Our Reference: SYD17/00398/02 (A19287936)
DP&E Ref: SSD 8344

**PROPOSED NORTH KELLYVILLE PUBLIC SCHOOL – LOT 100-101 DP 1216659, 120-126
HEZLETT ROAD, KELLYVILLE**

Reference is made to the Department of Planning and Environment (DP&E) letter dated 18 September 2017, regarding the abovementioned application which was referred to Roads and Maritime Services (Roads and Maritime) for comment.

Figure 2-10 – Bus stop in proximity to Kellyville North New Primary School

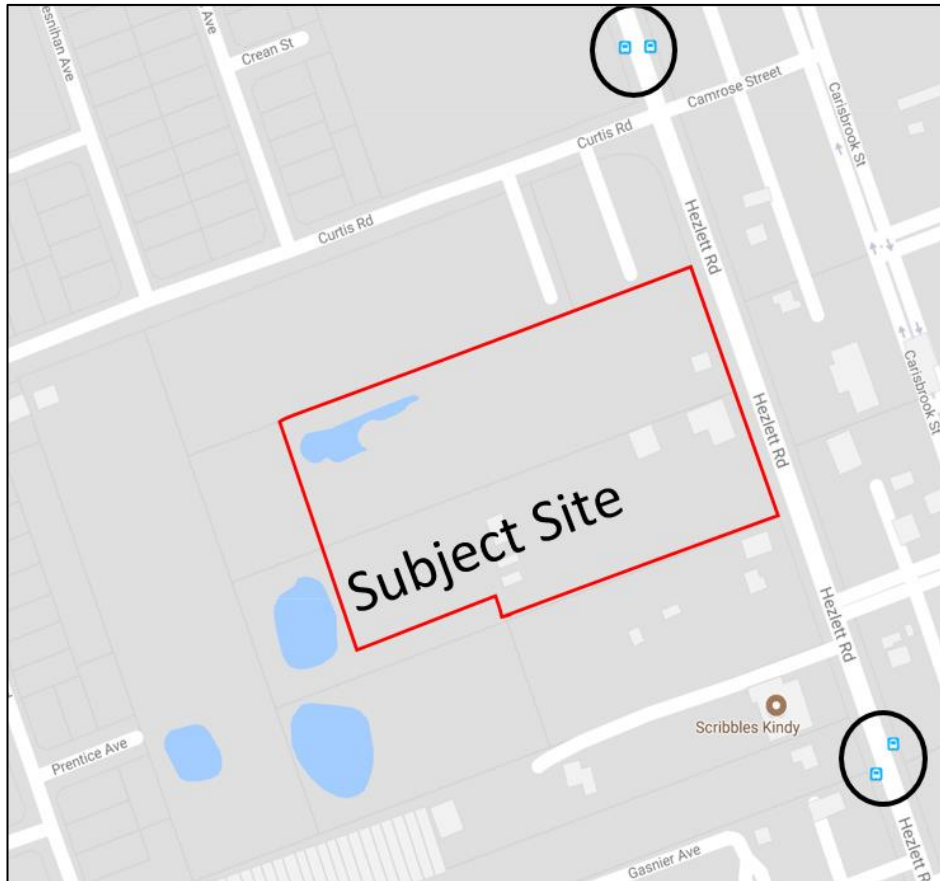
10. There are two bus stops located on both sides of Hezlett Road and in close proximity to the proposed development. The proponent should consult with TfNSW regarding the proposed development and for any proposed additional bus services/school buses as a result of the development. The proposed roundabout at the intersection of Hezlett Road/Curtis Road should cater for U-turn manoeuvre of buses.

Figure 2-11 – Cycling Routes in proximity to Kellyville North New Primary School

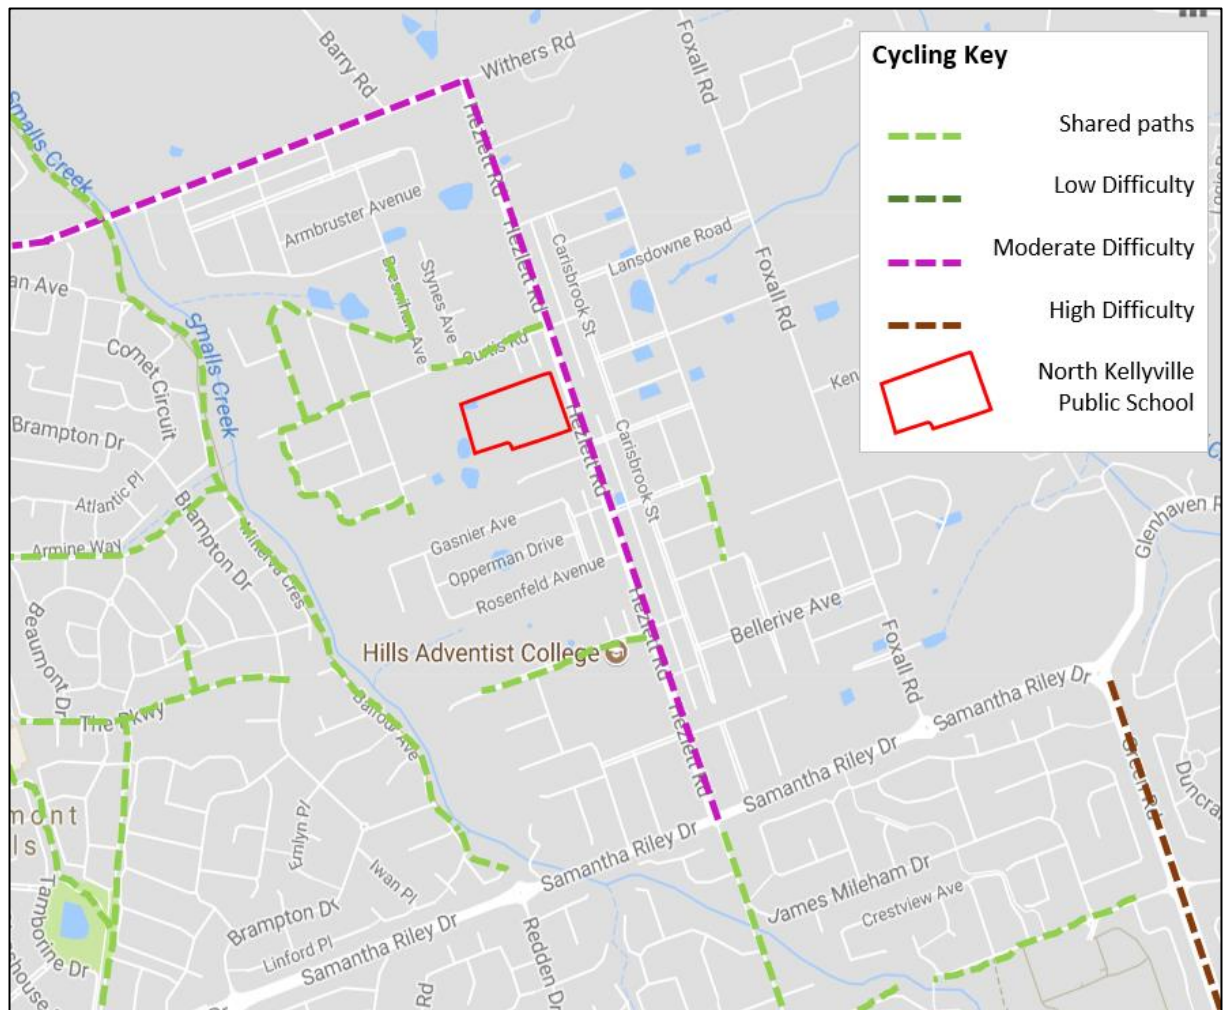
8. The development generates considerable pedestrian/cyclist movement to/from the school site. It is noted that there is no footpath/cycle facility in the vicinity of the site. Council should ensure that the required facility for active transport is in place to cater for the anticipated additional pedestrian/cyclist movement as a result of the development.
